### **Winsome Preliminary Plan Amendment, SP-21-2**

Please accept the following revised comments from El Paso County Public Health (EPCPH) regarding the project referenced above:

DATE	1/7/19
CHECKED	AS SHOWN
DRAWN	10/4/18
BY	NAME
9

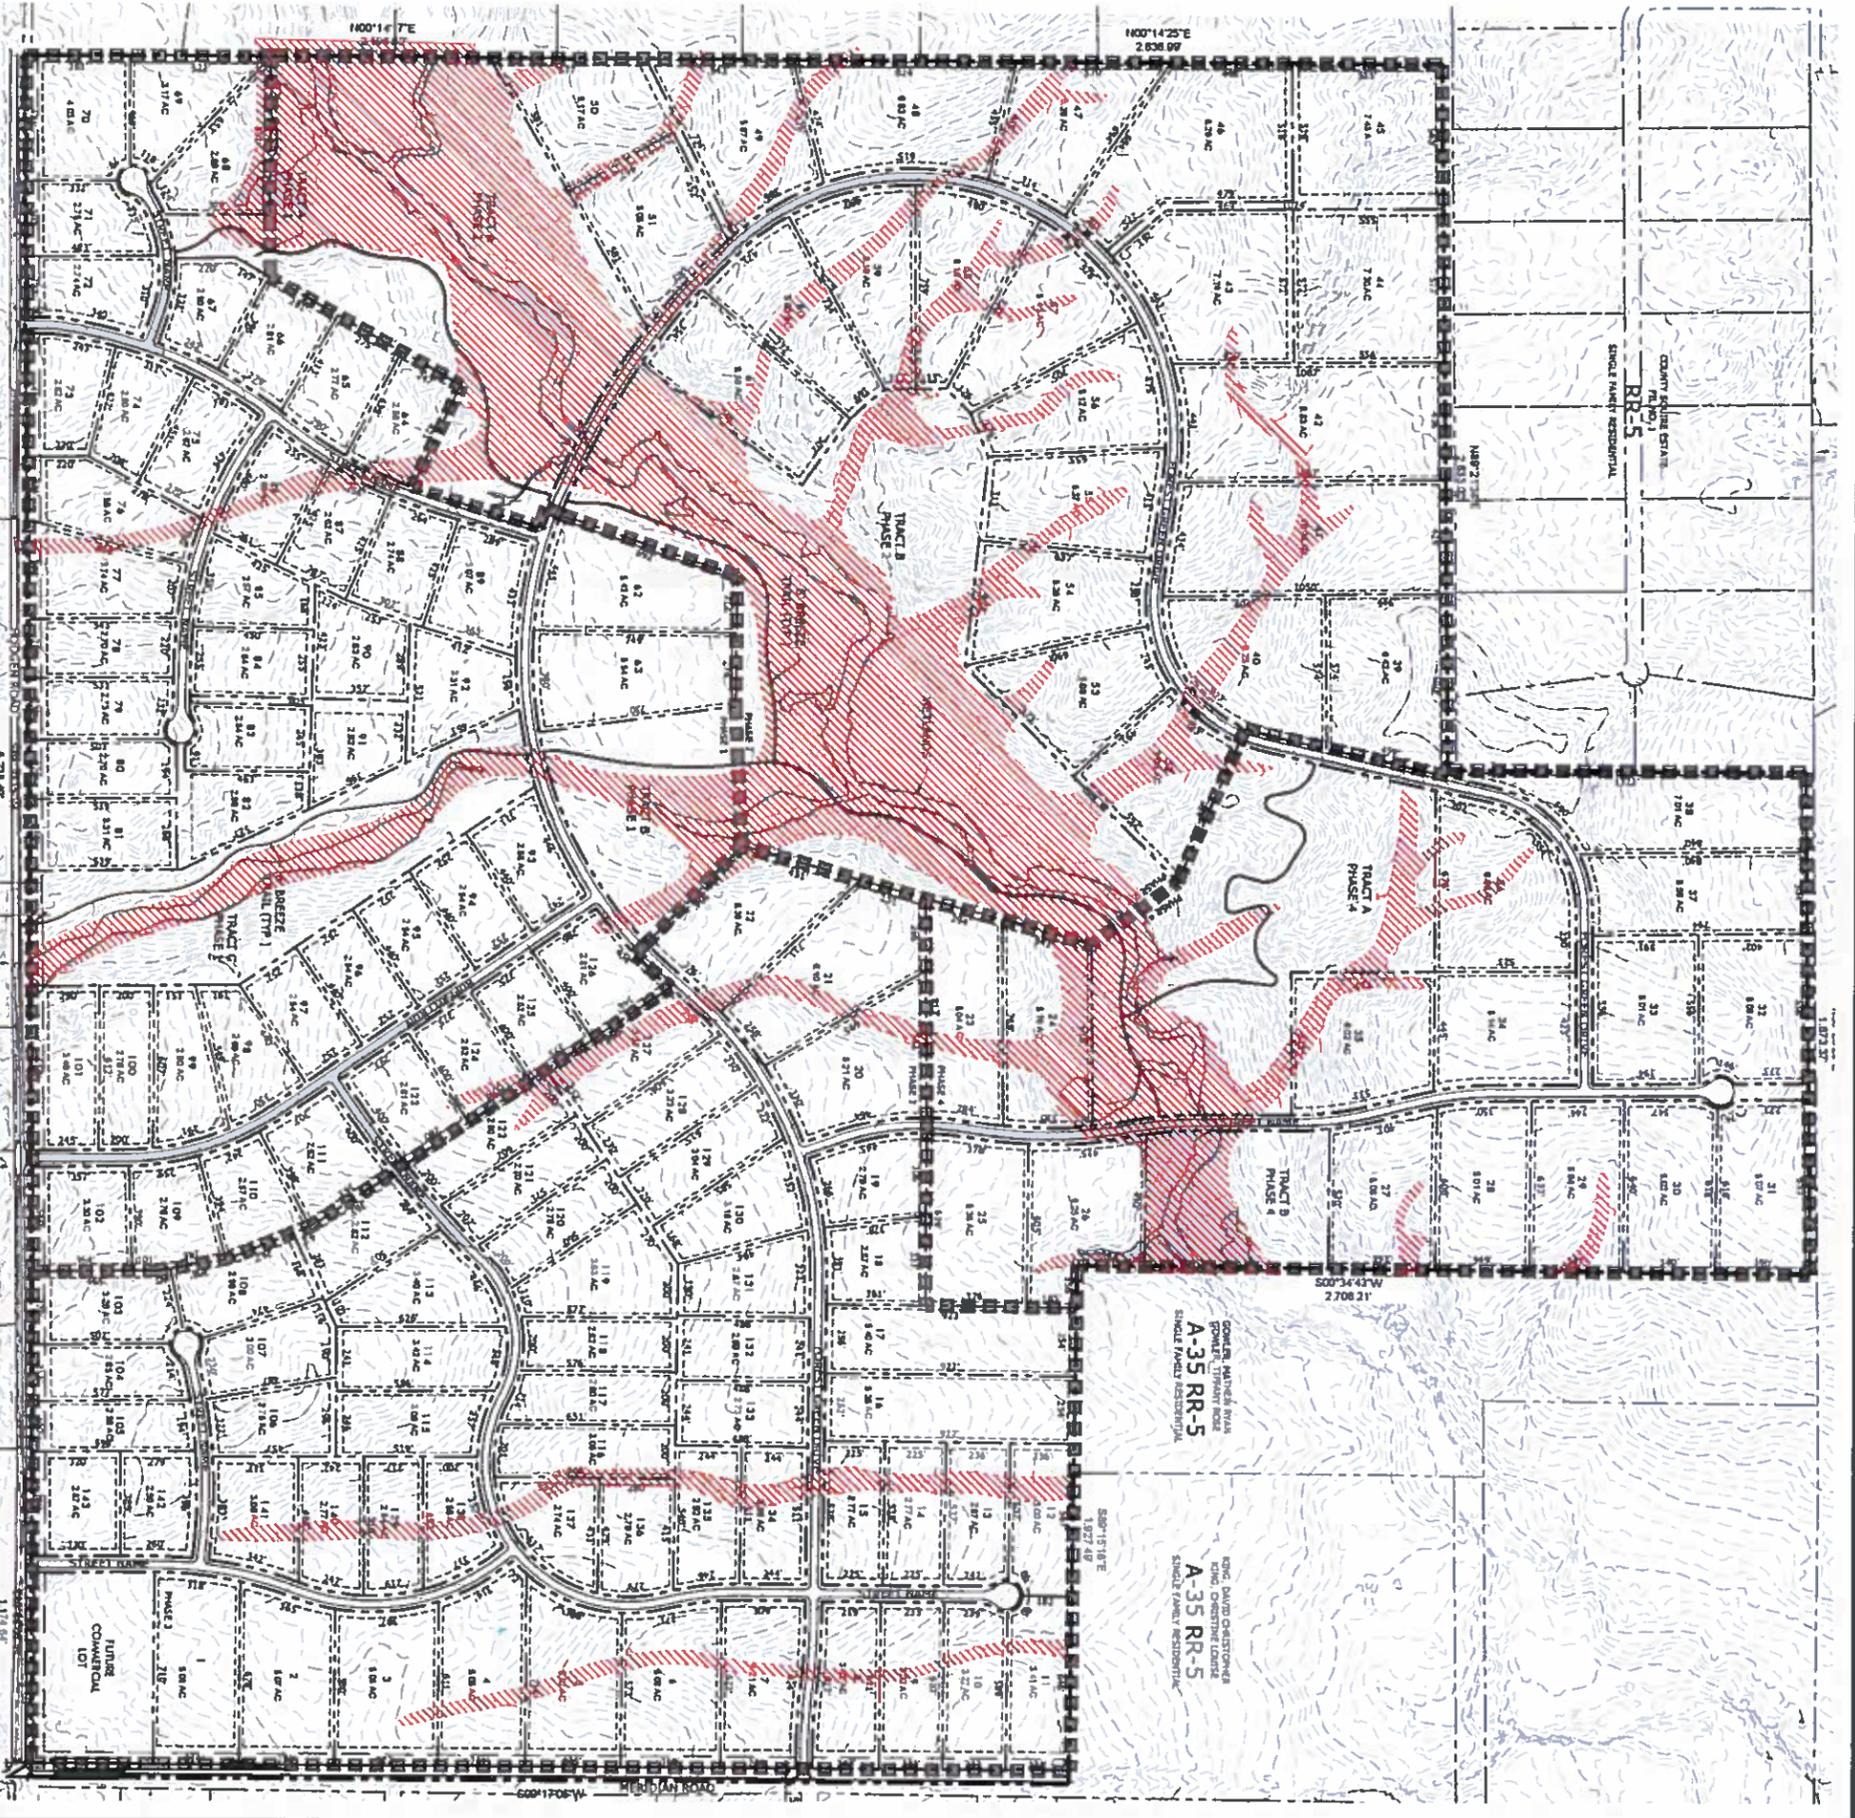
- Lots identified on the Entech Engineering 2018 Preliminary Plan Report (Figure 9) map show areas "Unsuitable for OWTS's" on several lots. Per a discussion held with Entech Engineering on 01May2019 these unsuitable

areas can be crossed by a driveway and/or OWTS piping or avoided entirely with proper homesite and well planning and placement.
